A585 Windy Harbour to Skippool Improvement Scheme

TR010035

7.11 Environmental Statement Changes and Corrections Document

~~August~~ July 2019

FIGURE 9.10

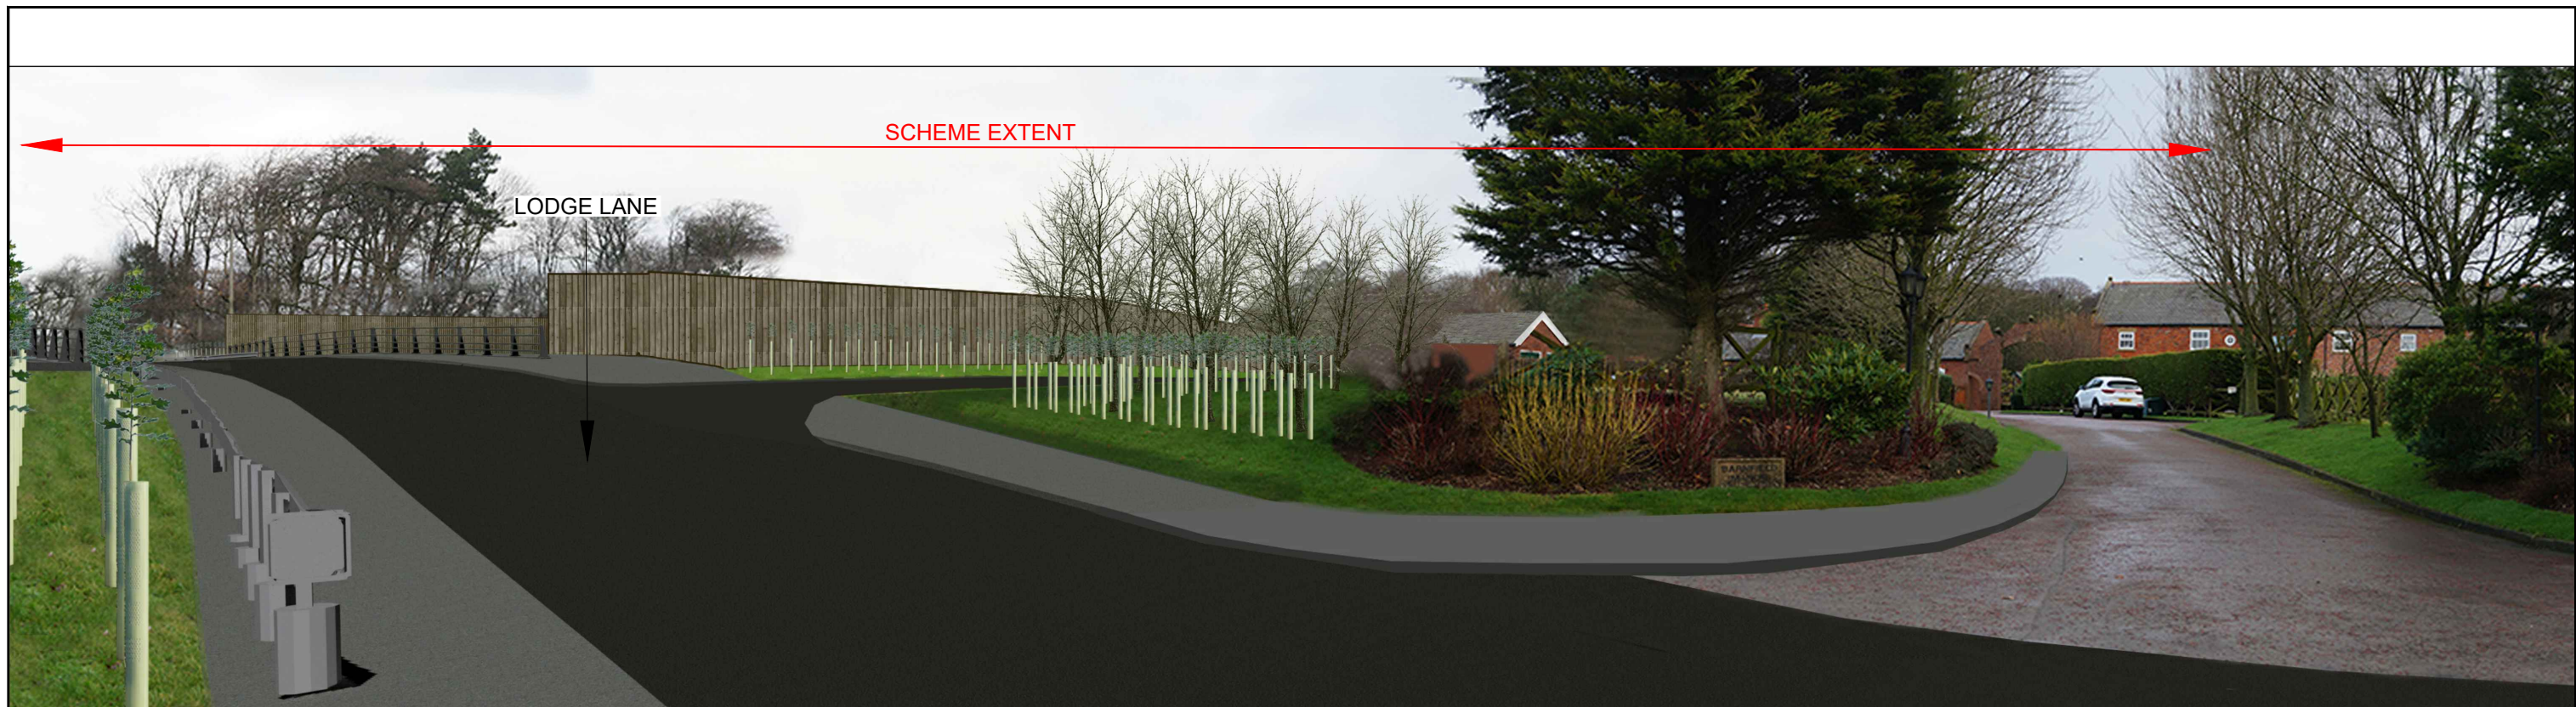
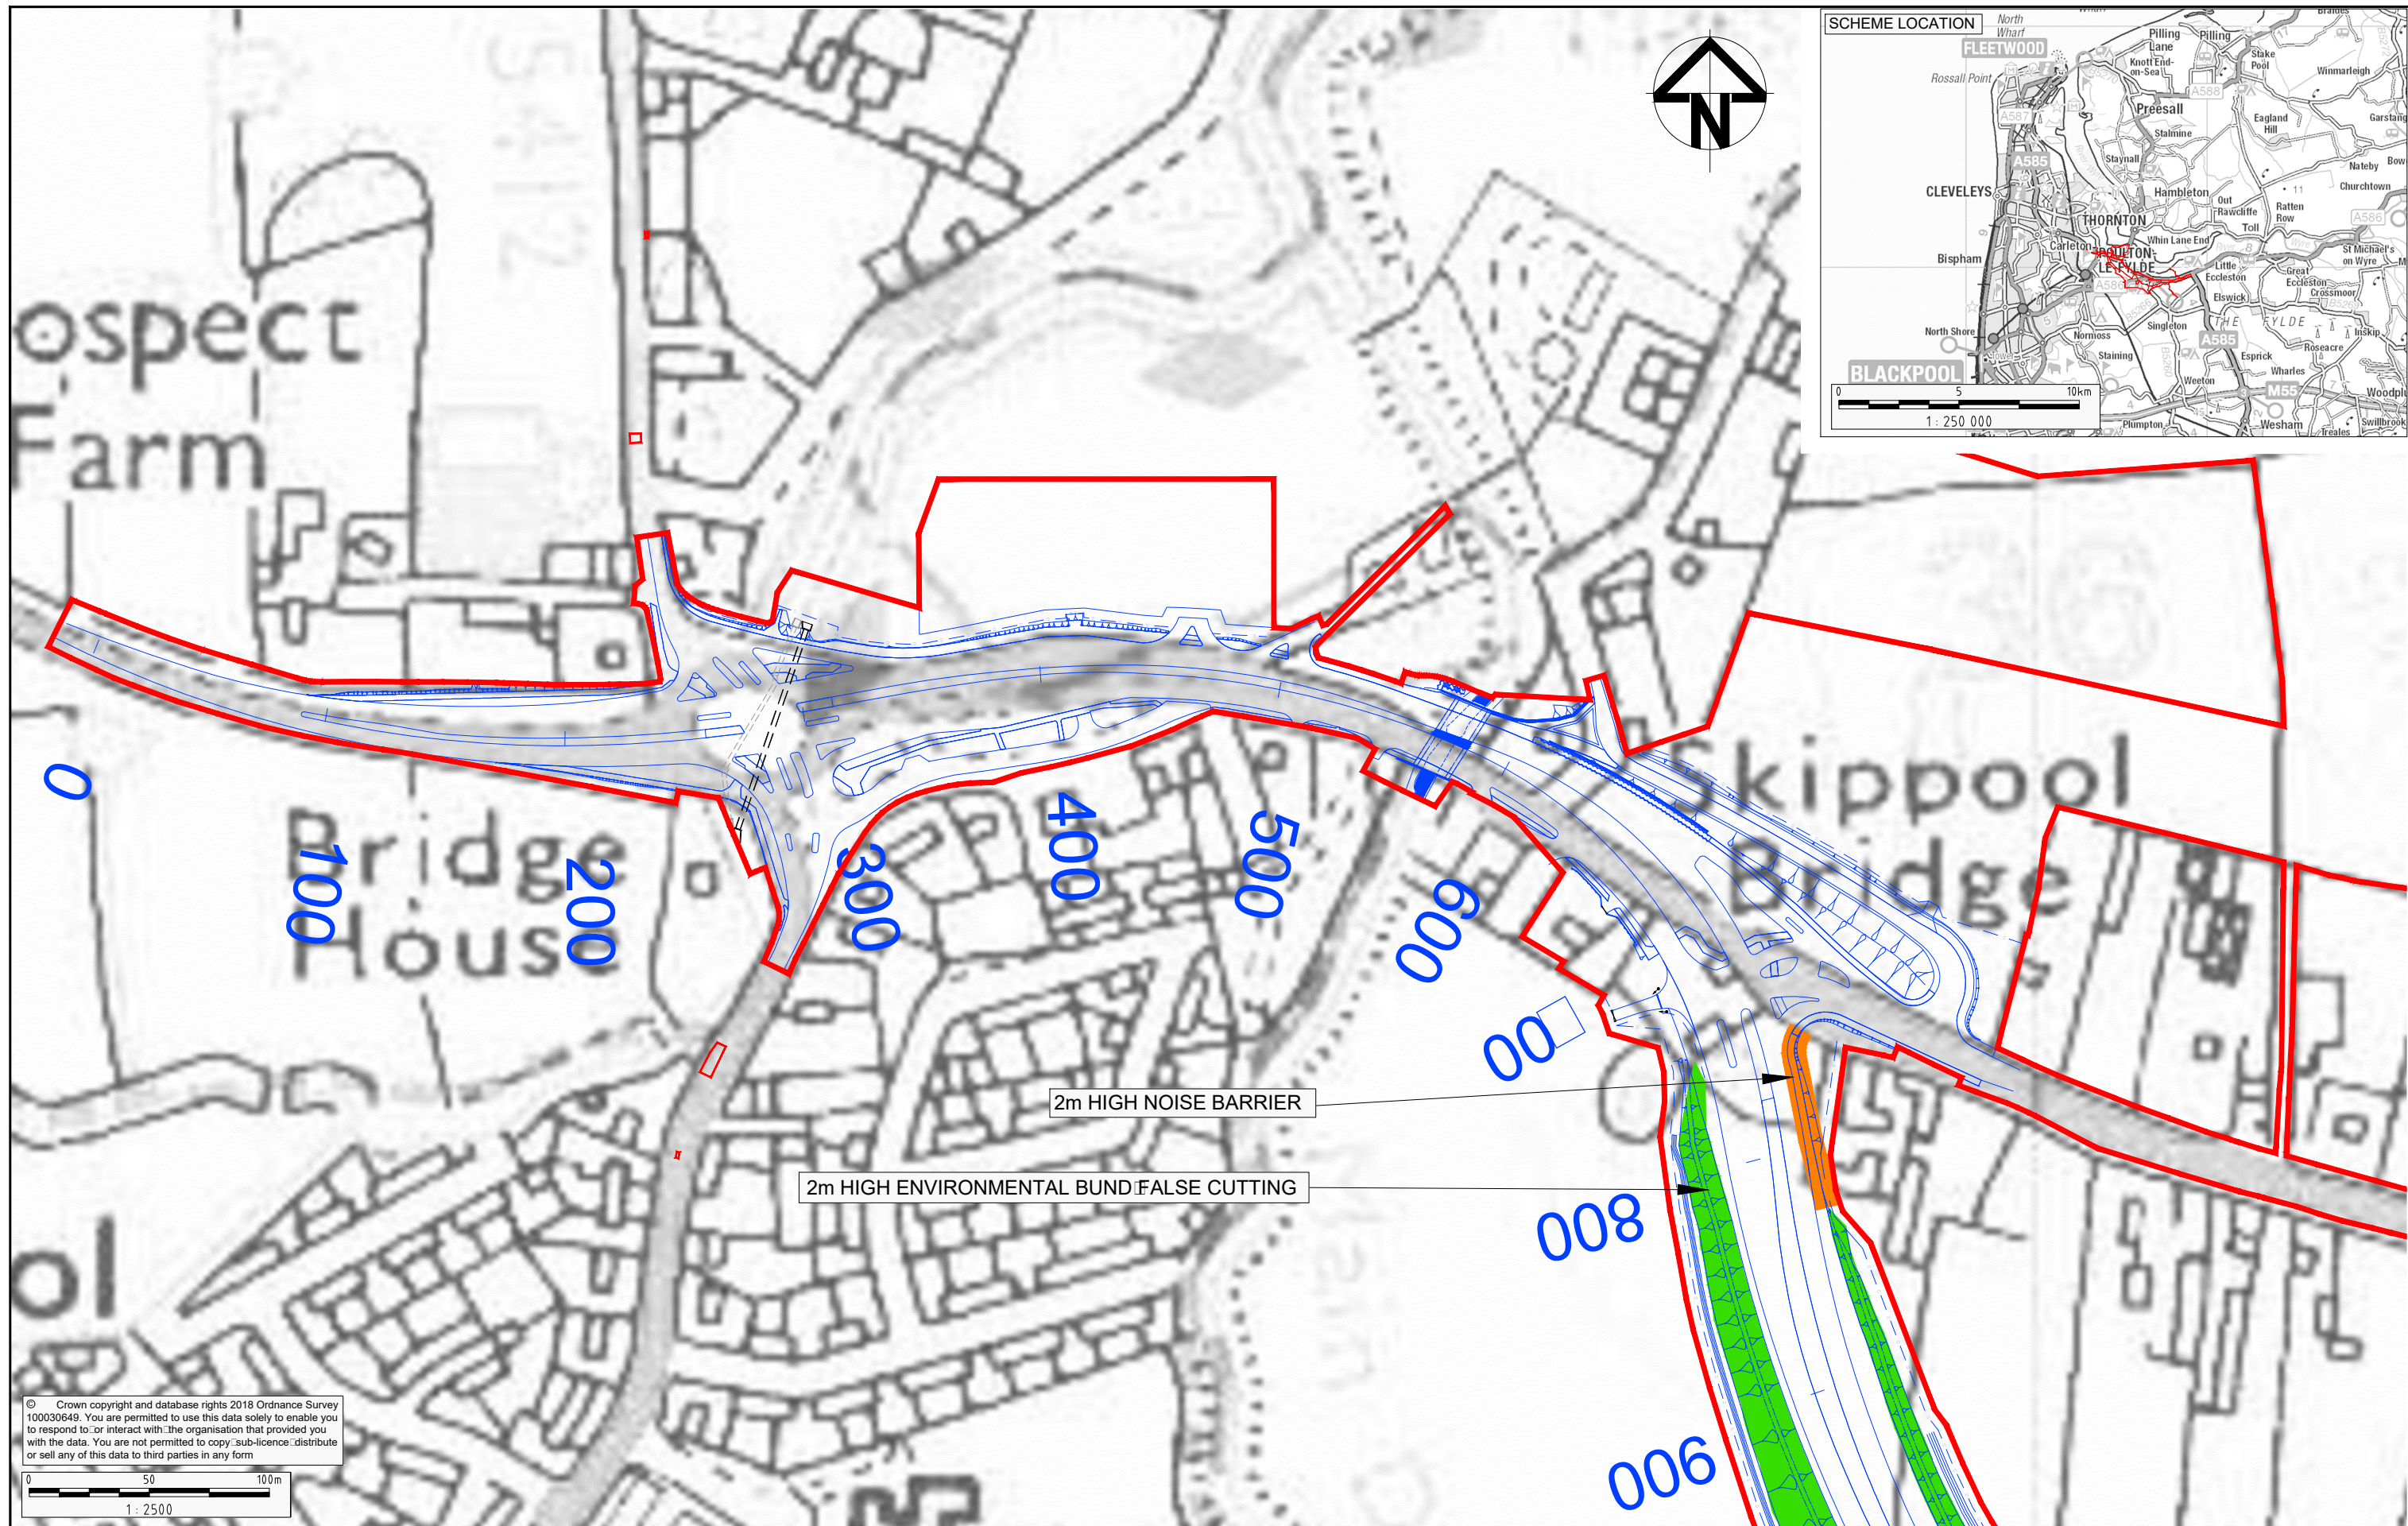
Document Reference Number	Document Name	Amendment Required	Reason									
6.9	ES Chapter 9: Landscape	Update to Figure 9.10, Photomontage at Viewpoint Location 1, view from Breck Road / Wyre Way at the A585 provided within Appendix C.	Updated to show the provision of a fence at 183 Breck Road.									
6.9	ES Chapter 9: Landscape	Update to Figure 9.10, Photomontage at viewpoint location 2 – Revision 2 , view from residential properties on Breck Road provided within Appendix C.	As a result of updates to the Flood Risk Assessment associated with the dwarf wall and the provision of a fence at 183 Breck Road.									
6.9	ES Chapter 9: Landscape	Update to Figure 9.10, Photomontage at viewpoint location 10, view from the B5260 Lodge Lane provided within Appendix C.	Updated to show the 3m high acoustic barrier to the north of the cutting.									
6.9	ES Chapter 9: Landscape	Update to Figure 9.10, Photomontage at viewpoint location 9, view from the A585 Garstang New Road provided within Appendix C.	Updated to show the additional linear planting adjacent to Grange Footbridge, as a result of request from Fylde Borough Council (document reference TR010035/APP/7.9).									
6.9	ES Chapter 9: Landscape	Update to Table 9-16

APPENDIX F – Updated Figure 12.2: Road Drainage and The Water Environment – Aquifers

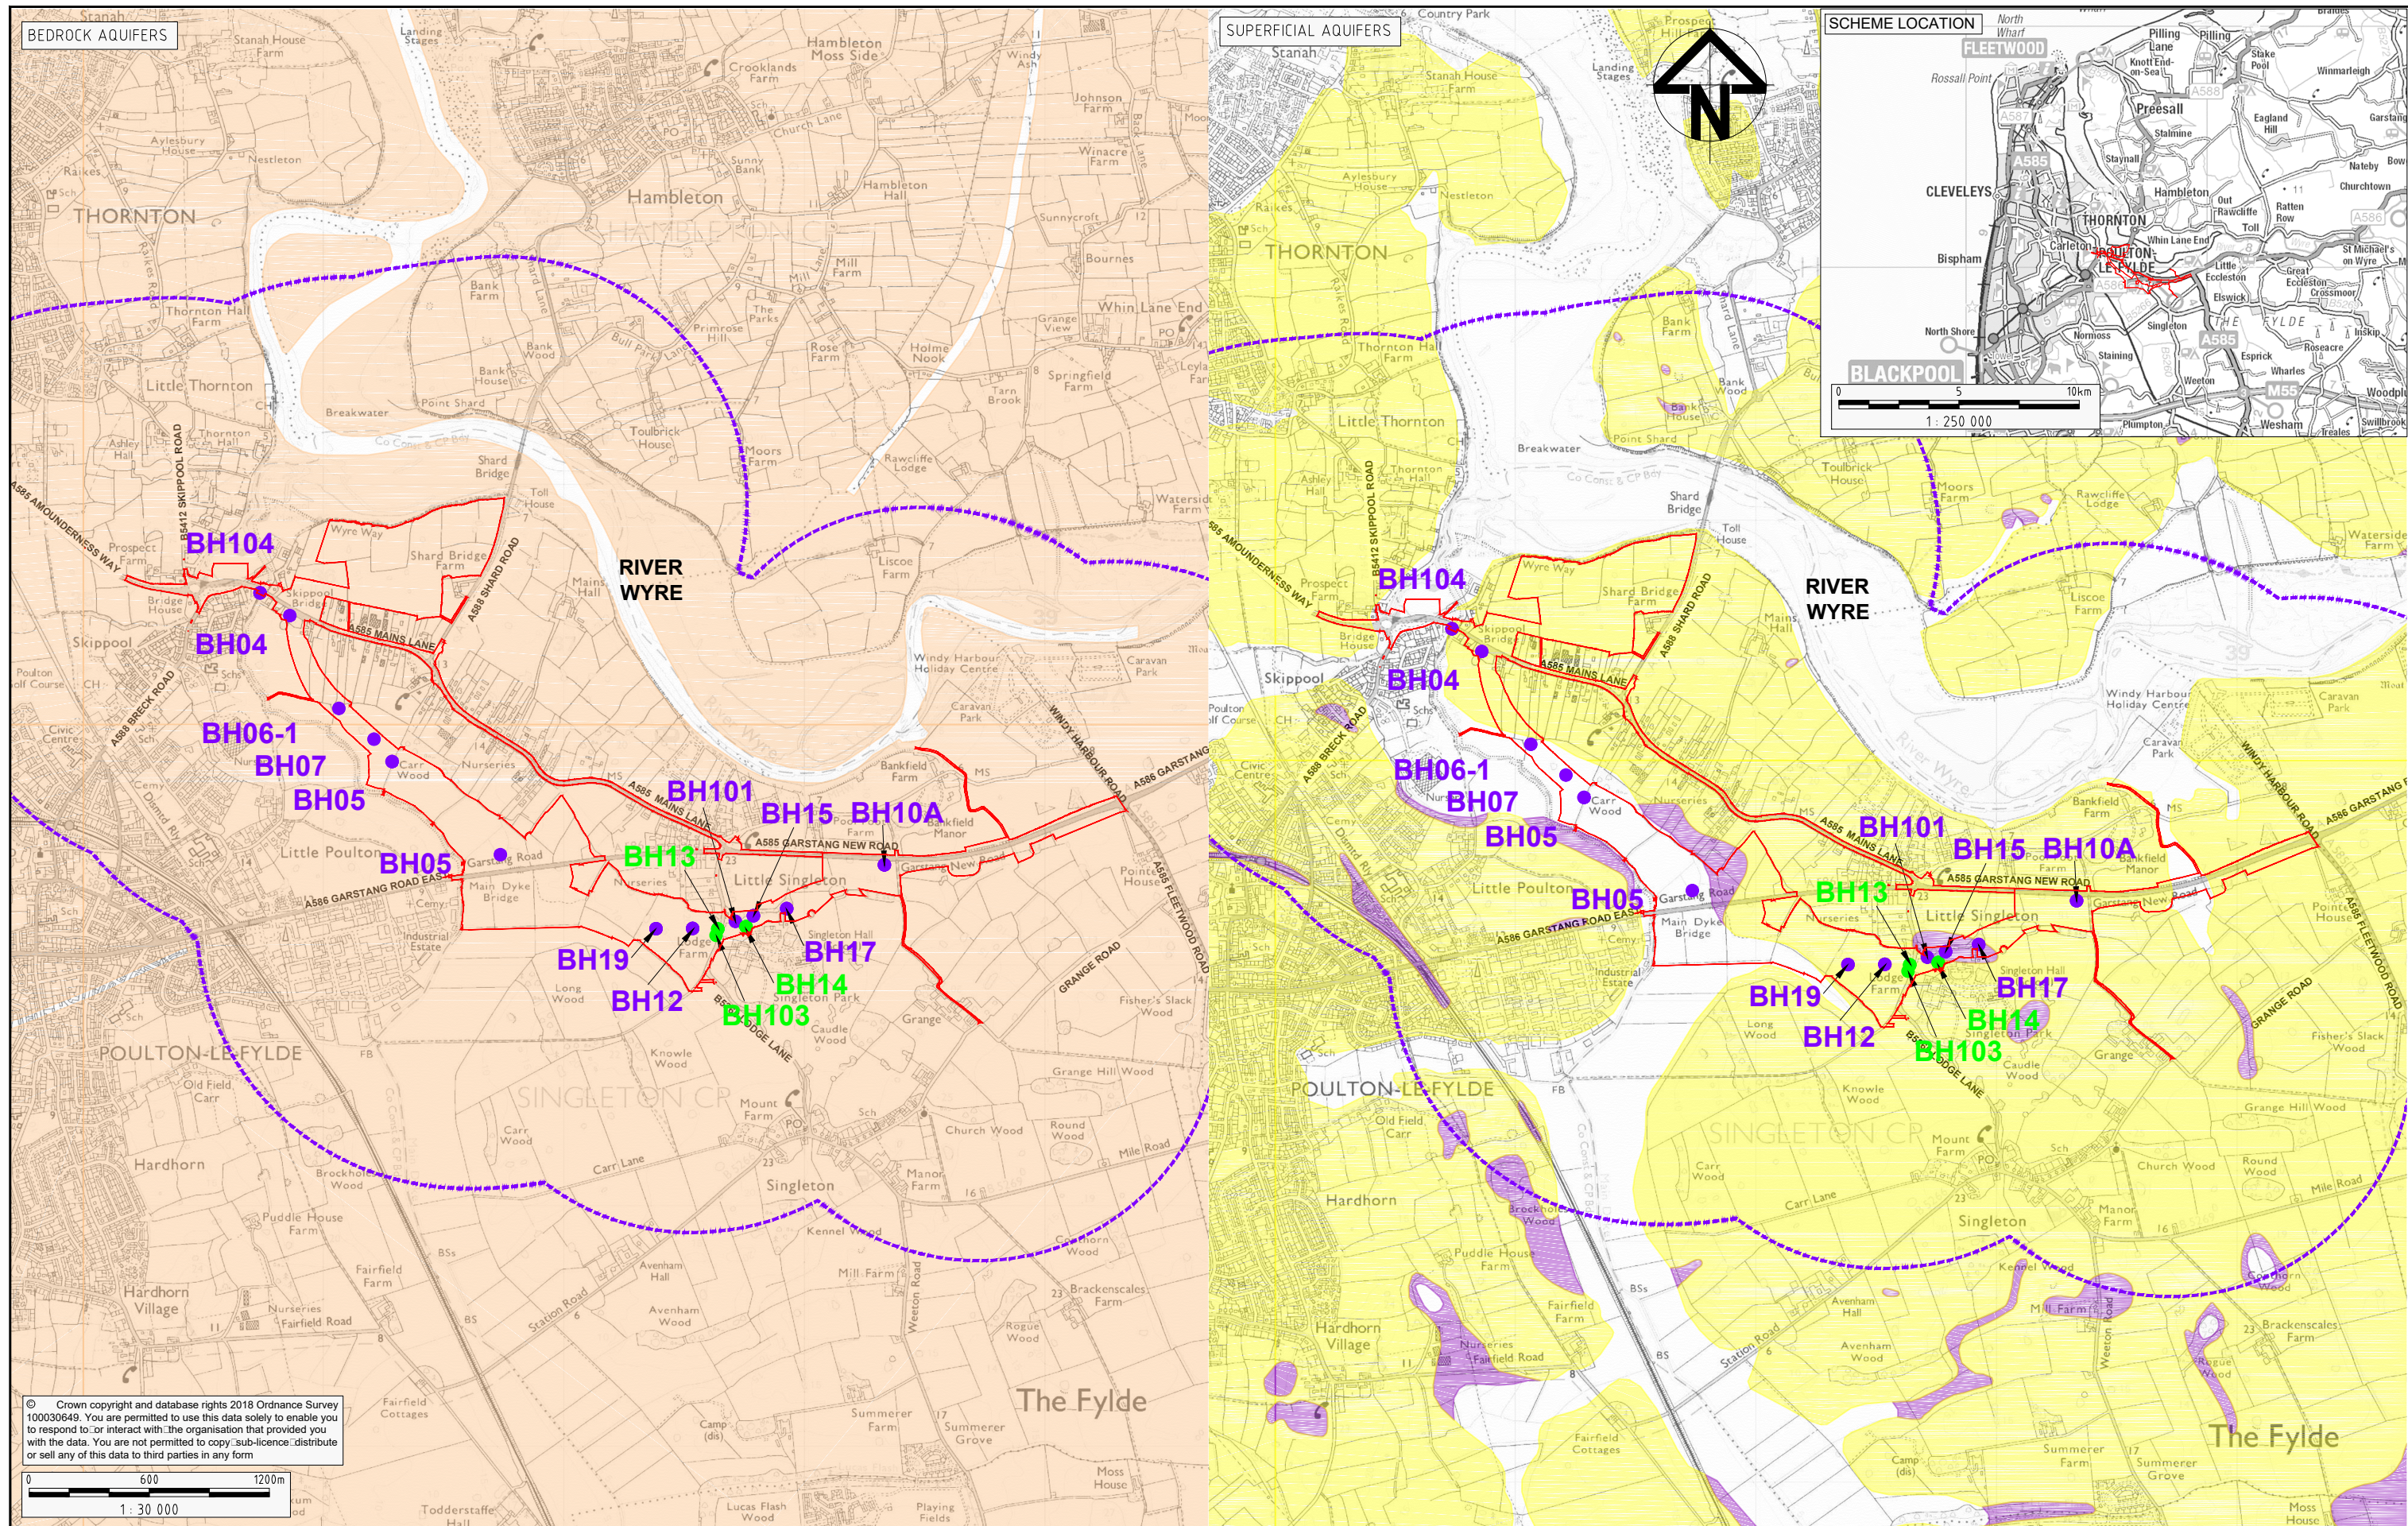
Appendix E – Updated Table 4-1 within Appendix 11.3 (document reference TR010035/APP/6.11.3).....	34
Appendix F – Updated Figure 12.2: Road Drainage and The Water Environment - Aquifers	36

Insert 12-3: Road Drainage and the Water Environment - Maximum flood Extents in Baseline and with Scheme (option model) Scenarios (0.5% AEP tidal event)

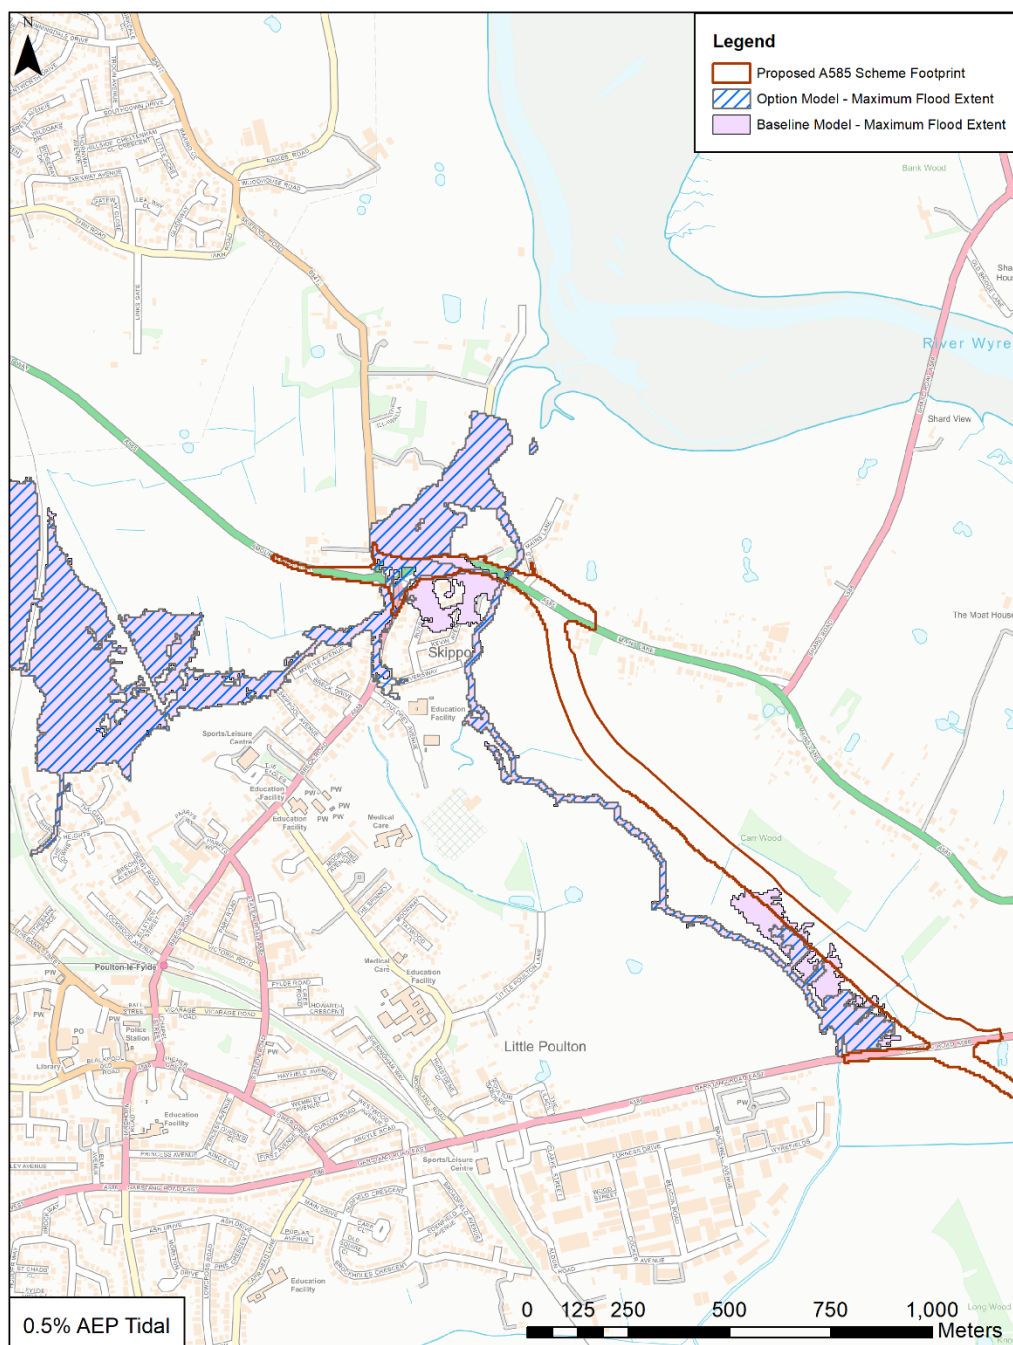
6.12	ES Chapter 12: Road Drainage and the Water Environment	Replacement Insert 12-3: Road Drainage and the Water Environment - Maximum Flood Extents in Baseline and with Scheme (option model) Scenarios (0.5% AEP tidal event).	As a result of the updates made to the Flood Risk Assessment (document reference TR010035/APP/5.2 – Rev 1).
